KITTITAS COUNTY

MEMORANDUM

TO: Kaycee Hathaway, Community Development Services
FROM: Christina Wollman, Planner III *CW*
DATE: September 16, 2014
SUBJECT: MTA Holdings BL-14-00016

**Anderson Hay and Grain Boundary Line Adjustment (BLA) :
Proposed Property Boundary Lines**

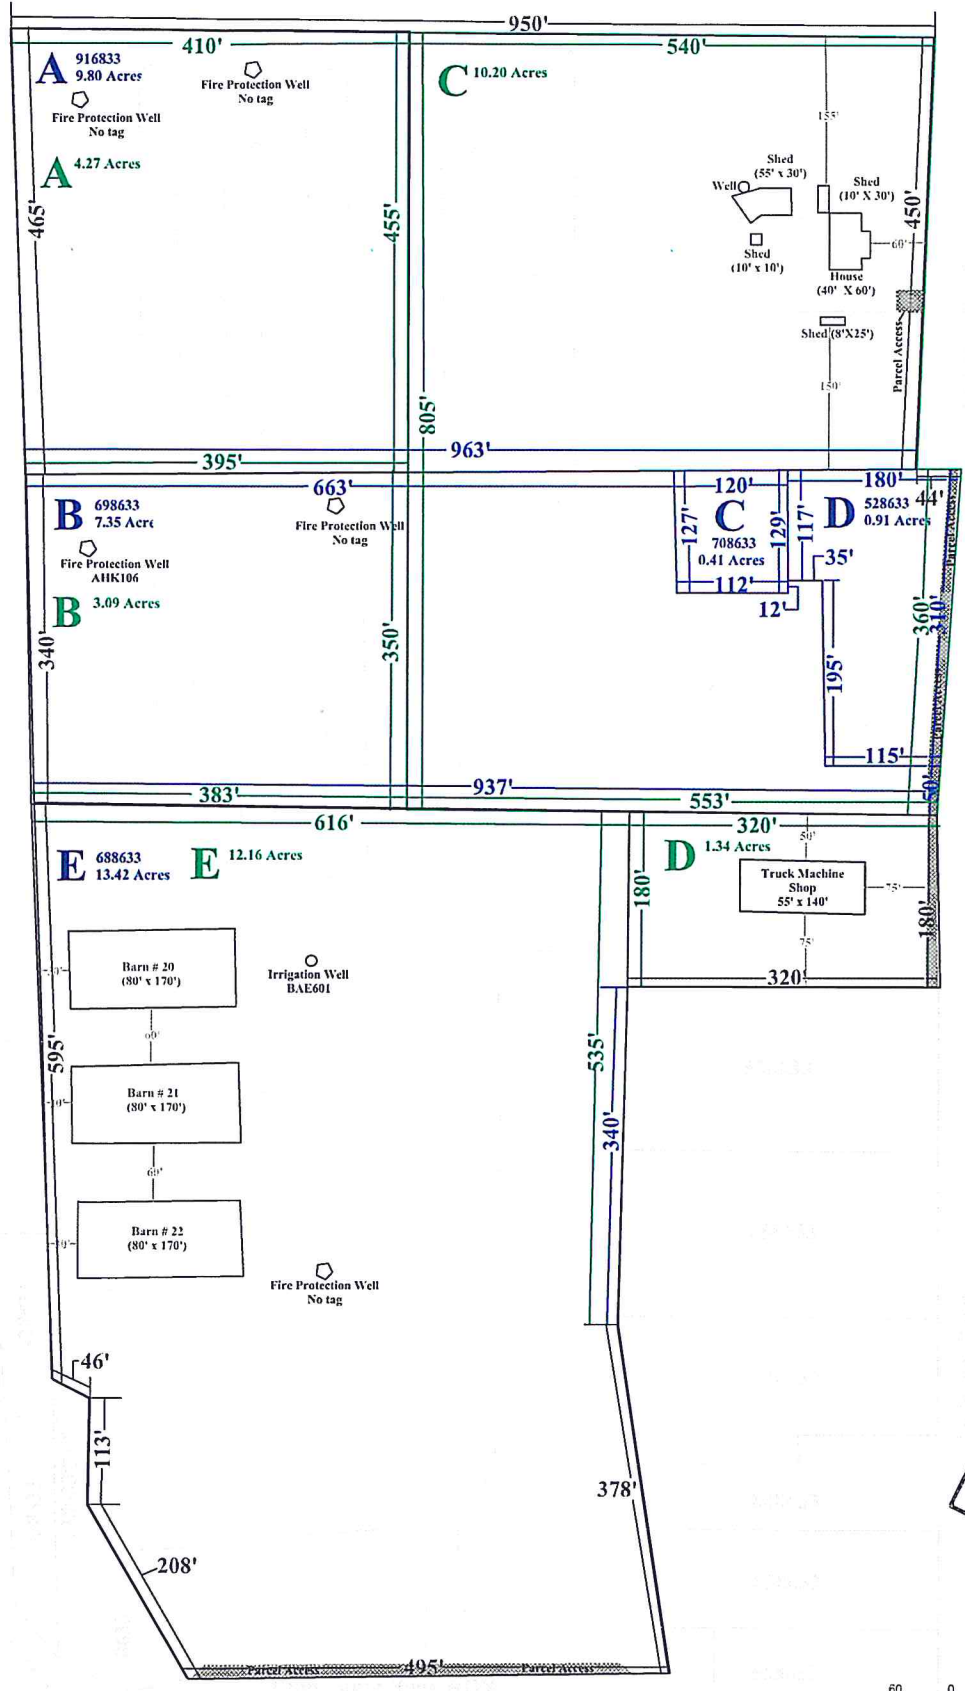
1. The proposed access with appropriate easement(s) shall be shown and shall conform to applicable Kittitas County Road Standards.
2. A revised legal description that describes the final configuration of the subject property shall be required.
